DRB CASE ACTION LOG (SITE PLAN – BUILD P.)

DRB Application No.: 08DRB-70151	Project # 1002270
Project Name: TERRACE ADDITION	
Agent: TOM LUCERO	Phone No.: 843-9283

**City of Albuquerque
Planning Department
Inter-Office Memorandum**

Date: April 1, 2008
To: Jack Cloud, DRB Chair 
From: Carol Toffaleti, Planner, Development Review
Subject: Project #1002270, 07EPC-400179 – The Cube Restaurant

GRADING AND DRAINAGE PLAN

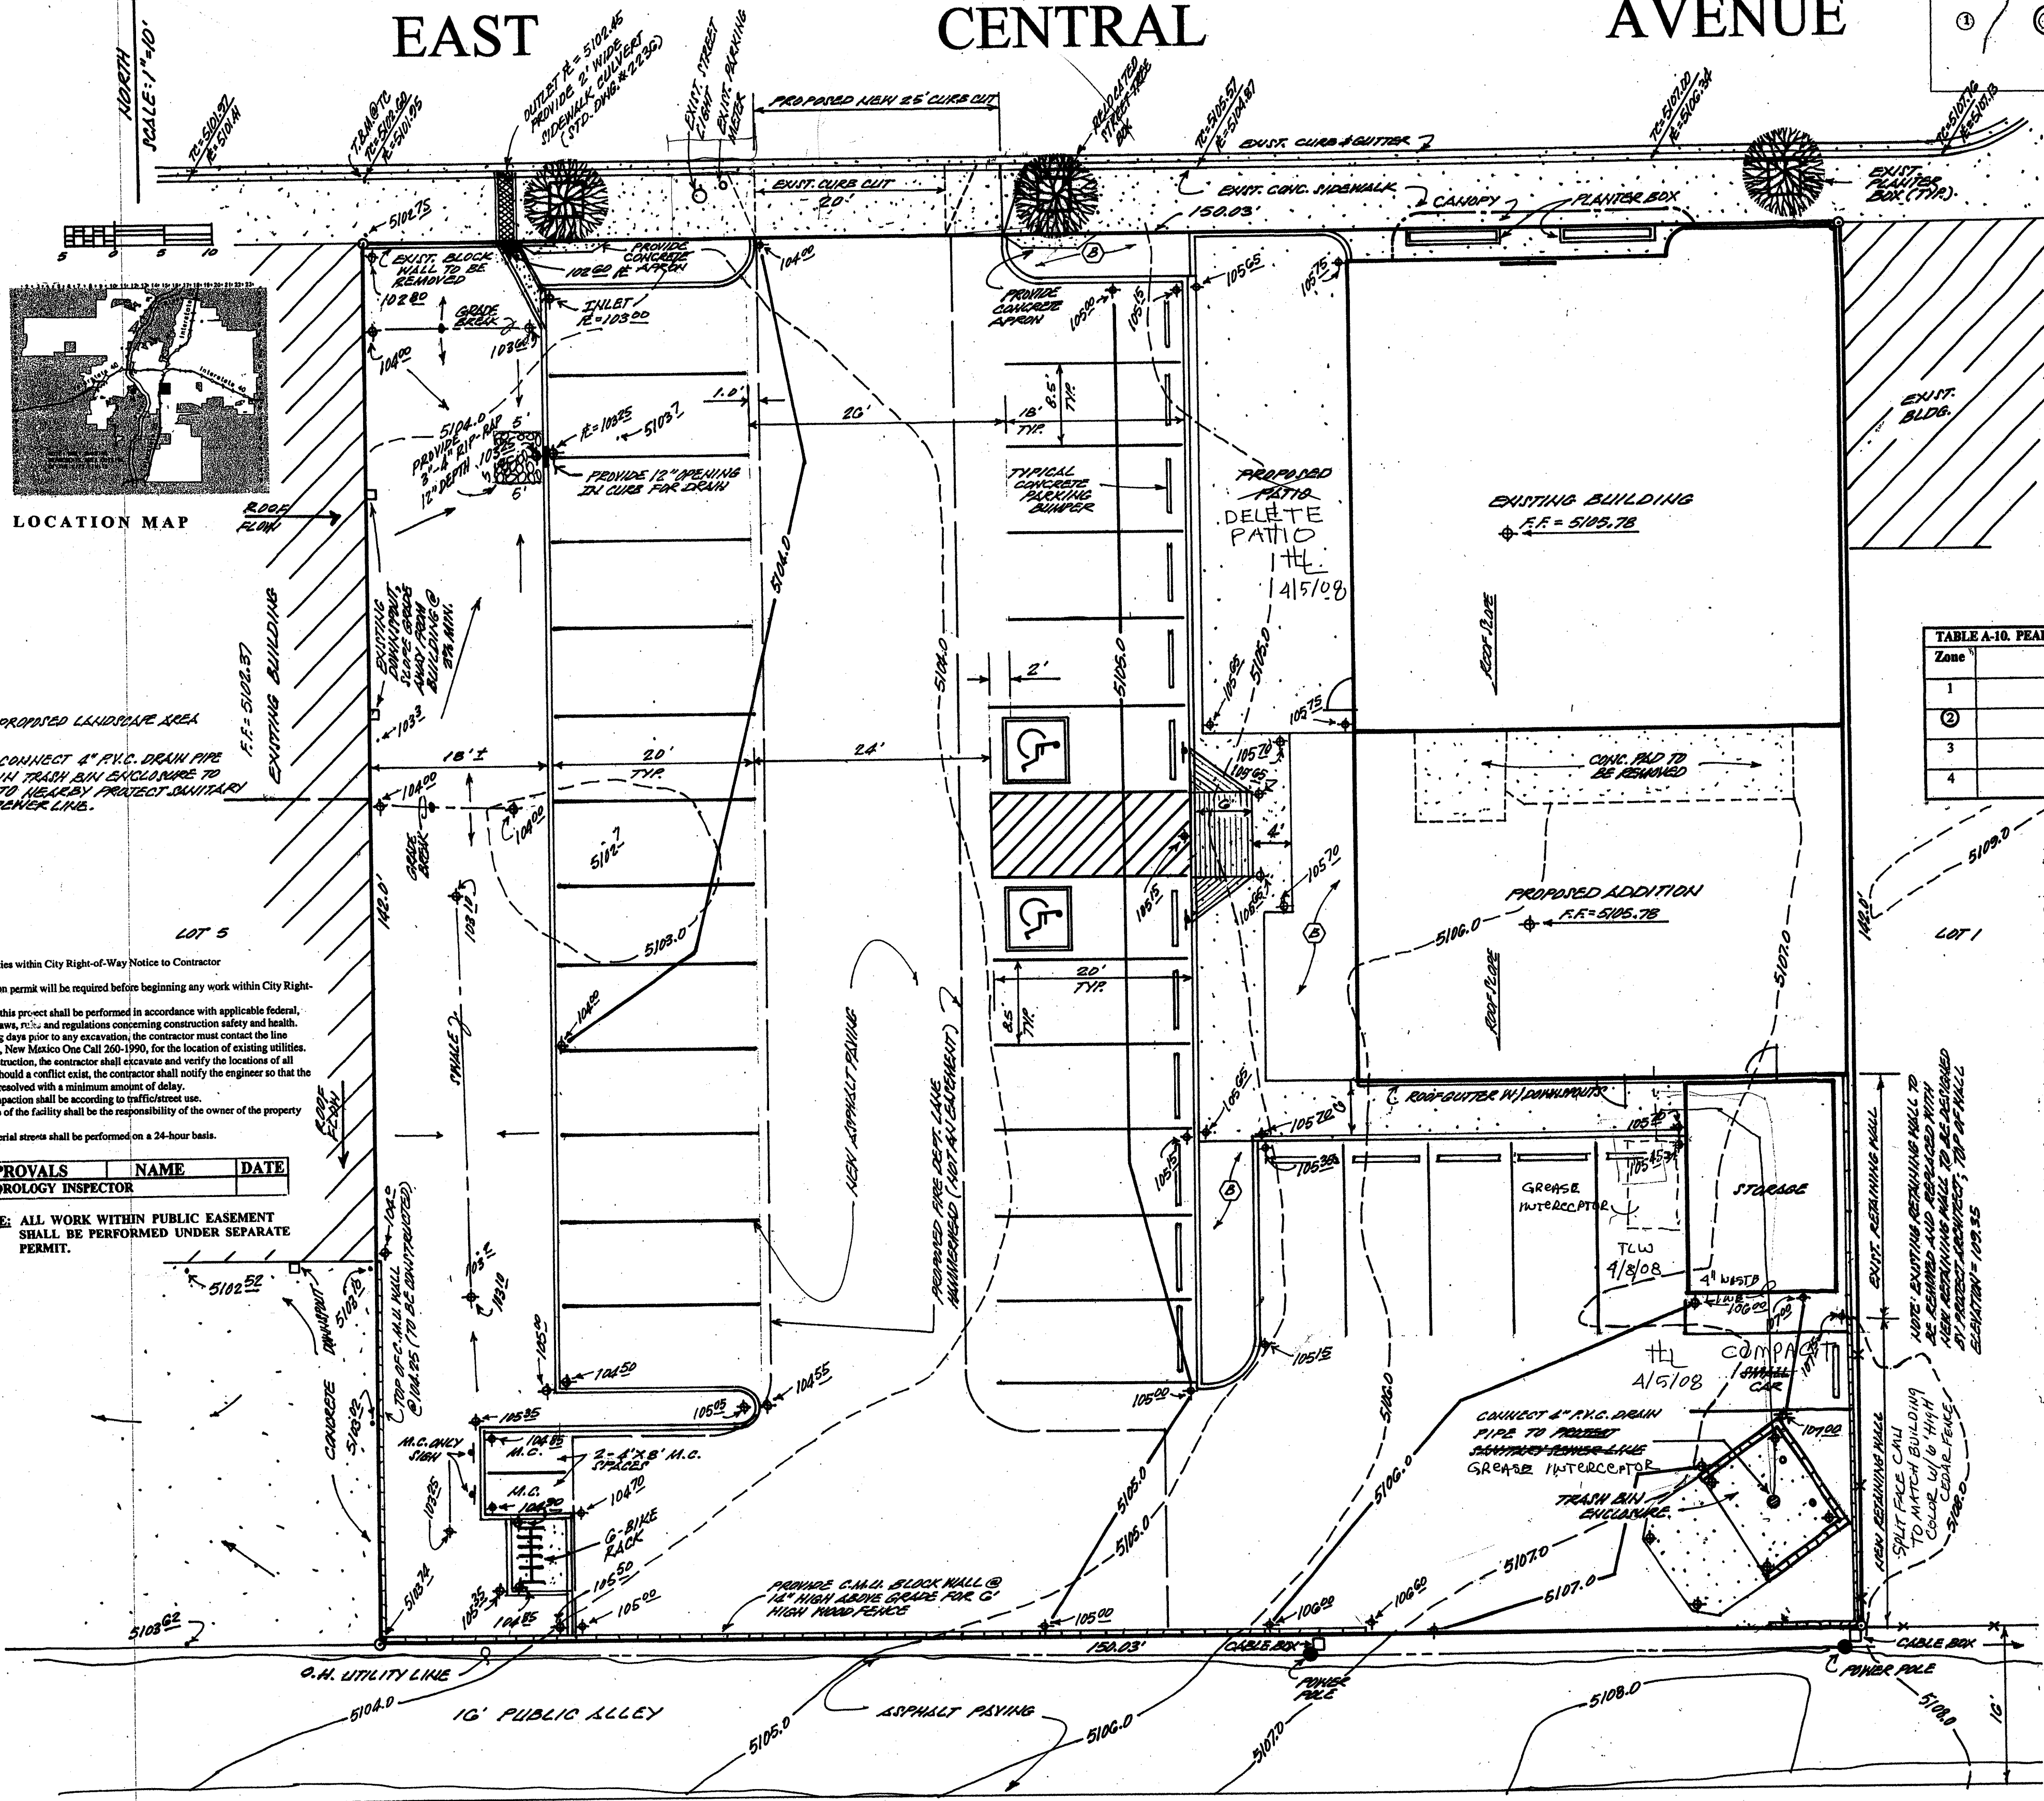
The new retaining wall and cedar fence shall be labeled accurately and consistently on all sheets of the submittal (Grading & Drainage, C-1, L-1 and S-1). The retaining wall is split face CMU to match building color.

SHEET NUMBER
S-1

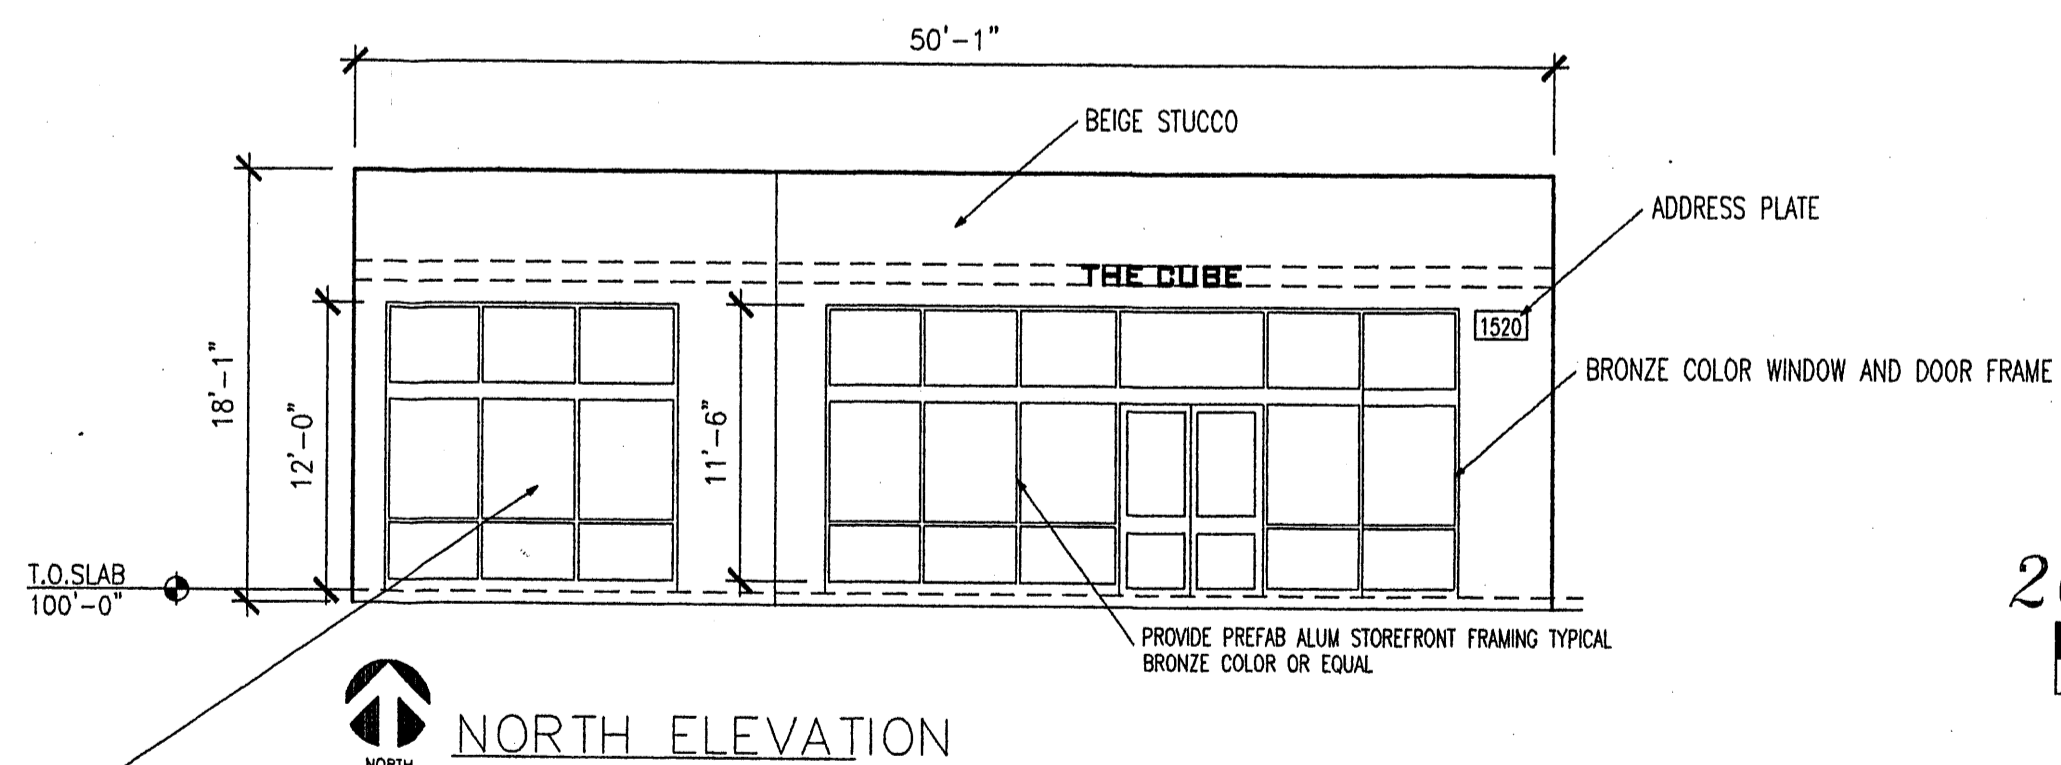
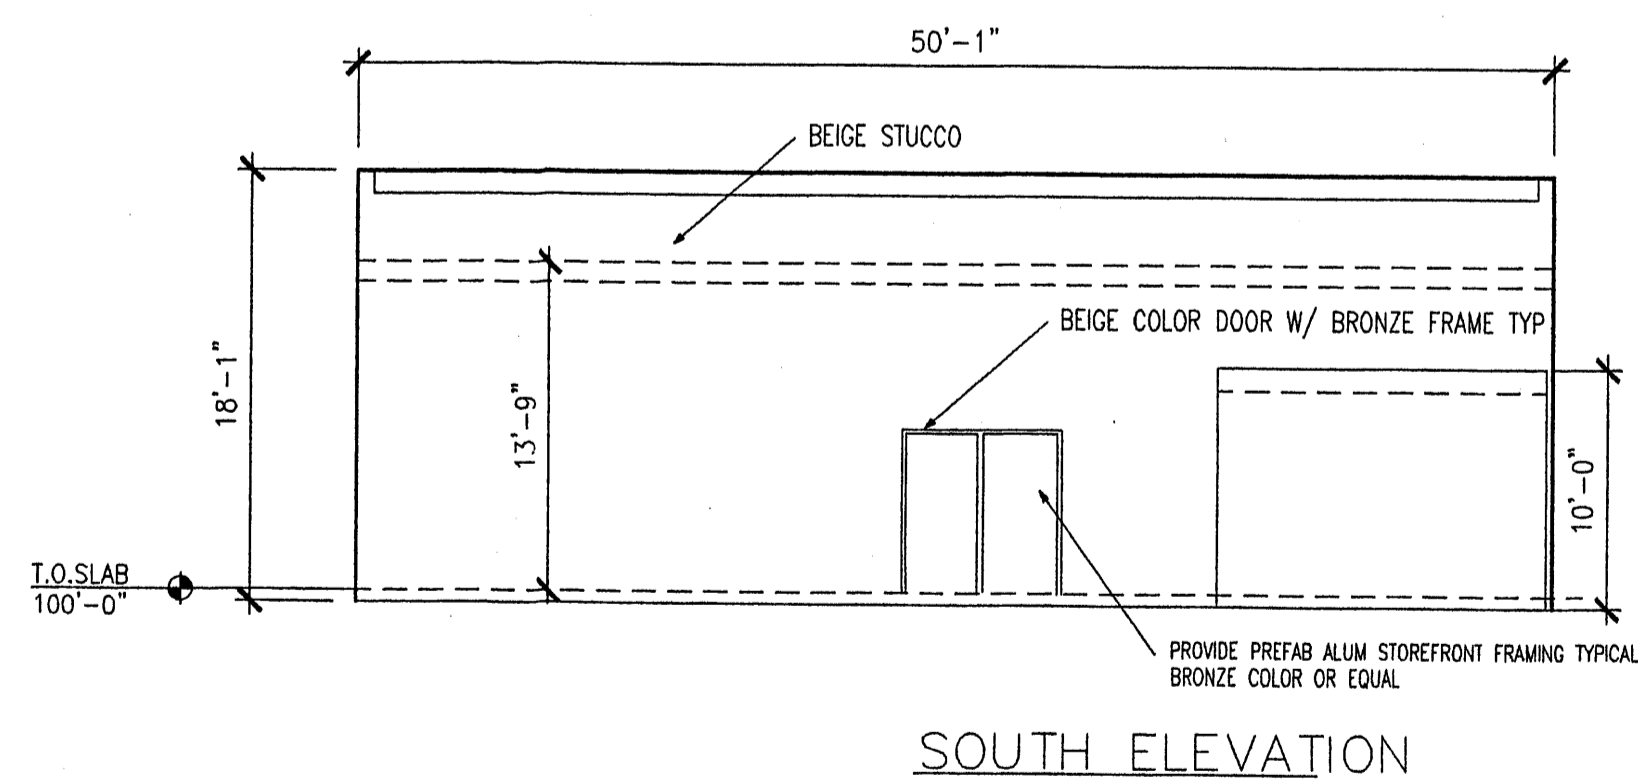
All references to an optional 6' CMU wall shall be deleted (Sheets C-1 and S-1).
